WEST SUSSEX COUNTY COUNCIL CONSULTATION

TO:	Arun District Council FAO: Michael Eastham
FROM:	WSSC - Highway Authority
DATE:	29 September 2021
LOCATION:	Land At Angels Nursery Yapton Road Barnham PO22 0AY
SUBJECT:	BN/119/21/DOC Approval of details reserved by condition imposed under ref BN/84/20/PL relating to Condition Nos 14 - access & associated off-site highway works, 15 - internal roads & associated infrastructure, 18 - disused crossovers and/or accesses no longer required and 21 - Travel Plan.
DATE OF SITE VISIT:	n/a
RECOMMENDATION:	More information required
S106 CONTRIBUTION TOTAL:	n/a for purposes of this planning application

This is the WSSC Highways (CHA) response to the above planning application for approval of details reserved by condition imposed under ref BN/84/20/PL relating to Condition Nos 14 - access & associated off-site highway works, 15 - internal roads & associated infrastructure, 18 - disused crossovers and/or accesses no longer required and 21 - Travel Plan.

STATUS	DRAWING SUBMITAL
A1	
REVISION	RHS STATUS
C1	STAGE 5 - CONSTRUCTION
DRAWING No.	
19812-GS-Z1-XX-DR-C-1014

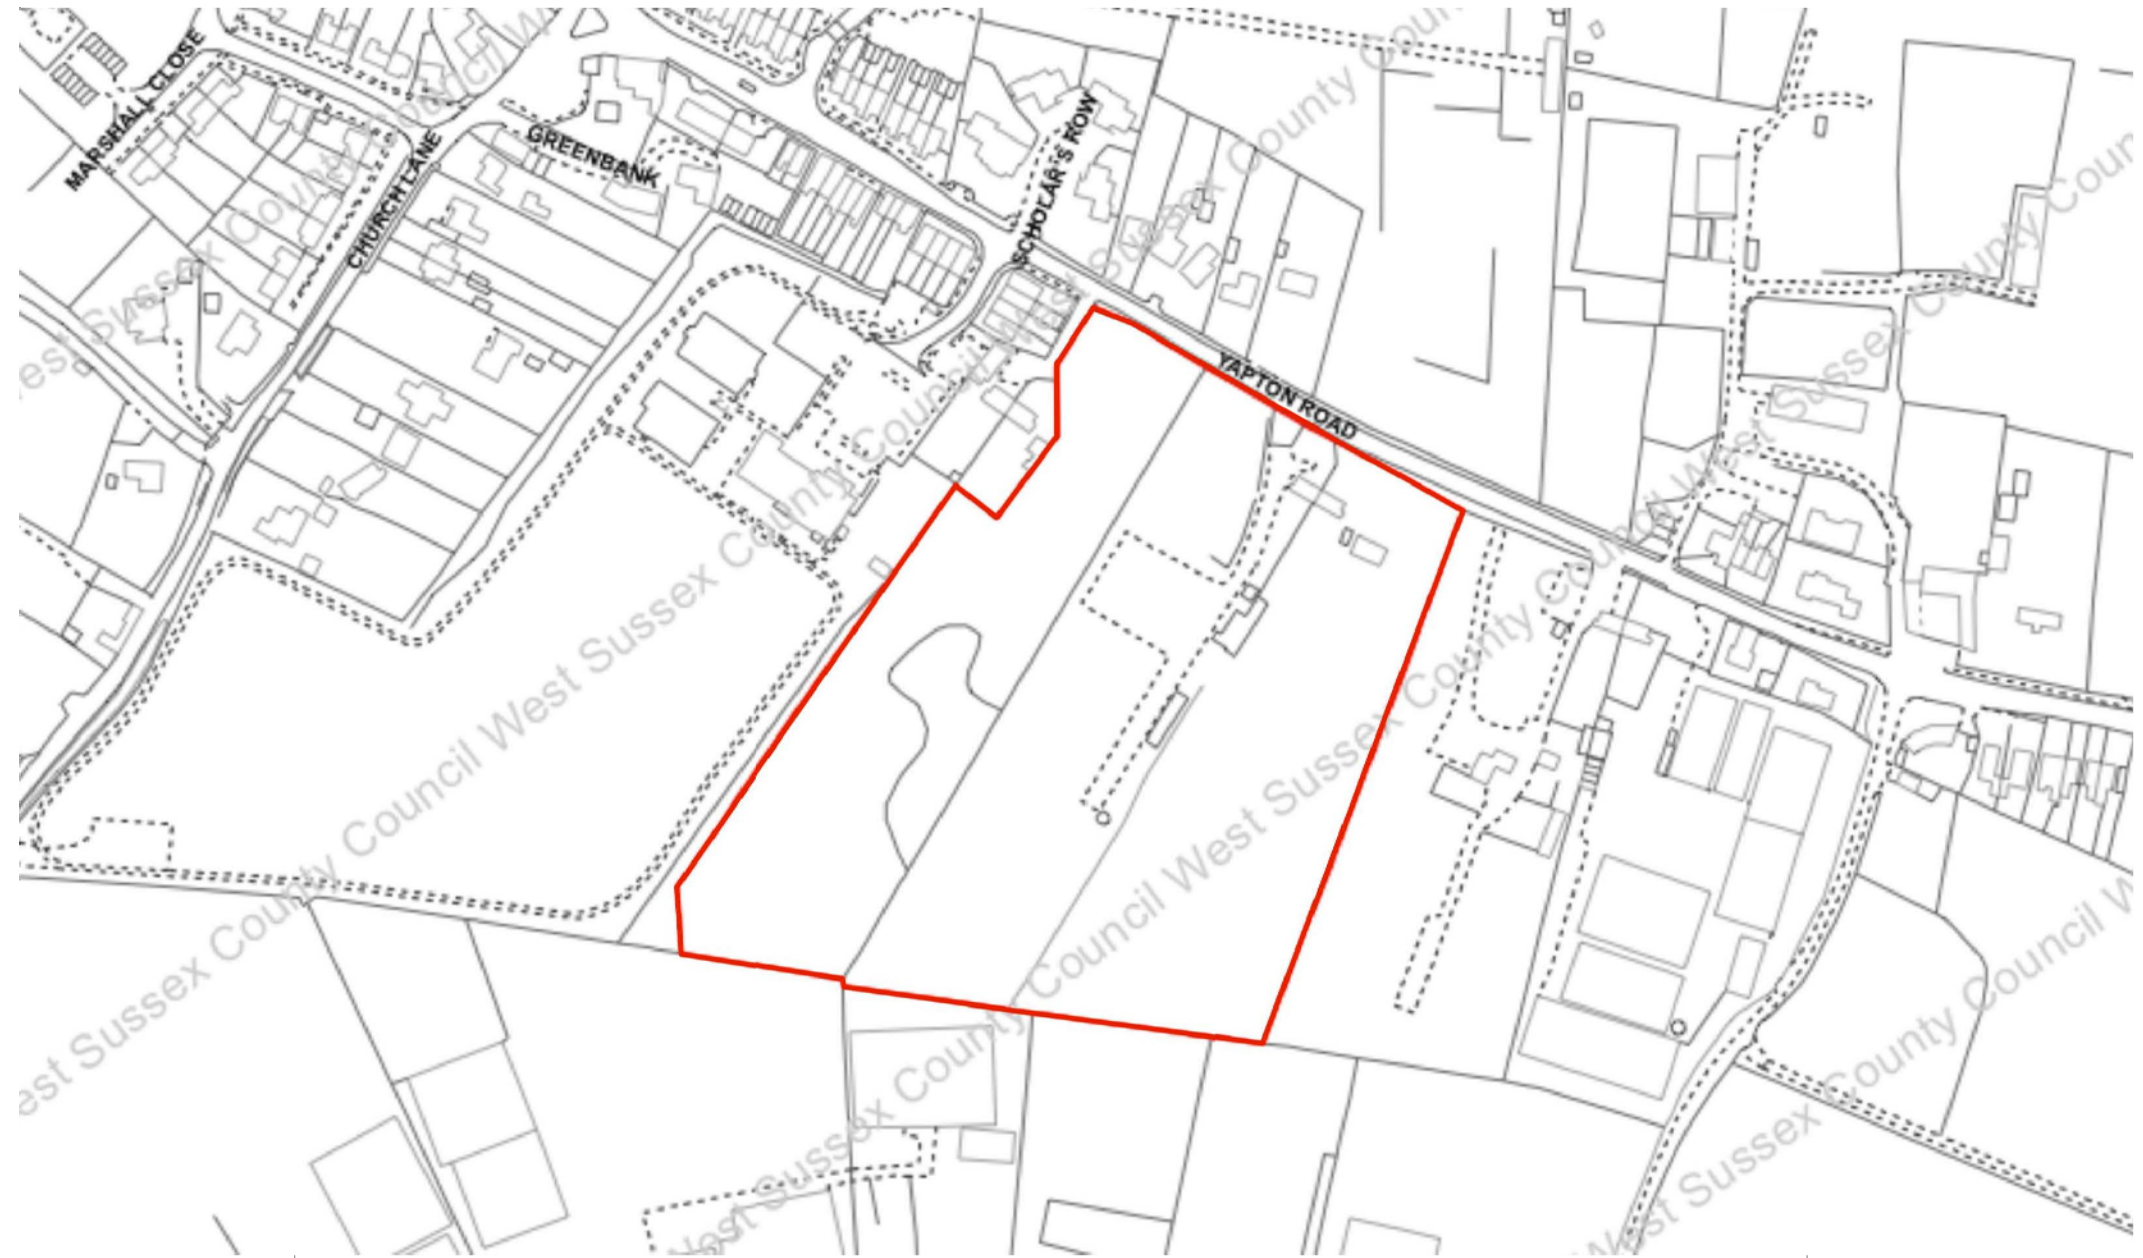
1. Condition 14 (access and associated highways works) – Drawing 19812-Z1-XX-DR-C-1014 Rev. 'C' has been provided. However, at the time of writing the latest drawing that WSSC is aware of being used for S38/278 purposes is Rev. 'C1'. This (or any subsequent approved drawing) should be referenced in any planning permission granted for this DOC application.
2. Condition 15 (internal roads and associated infrastructure) – 'External Works' drawings sheets 1 and 2 – No.'s 19812-GS-Z1-ZZ-DR-C-2080 and 19812-GS-Z1-XX-DR-C-2081 show the internal road layout and associated surfacing materials for roads, private drives, footways and footpaths etc. With regard to the layout, some minor changes are required. They are as follows:
 - Tie-in of cycle route to-and-from access road and shared-use path opposite Plot 6 to be better-defined. Location as follows (PTO):
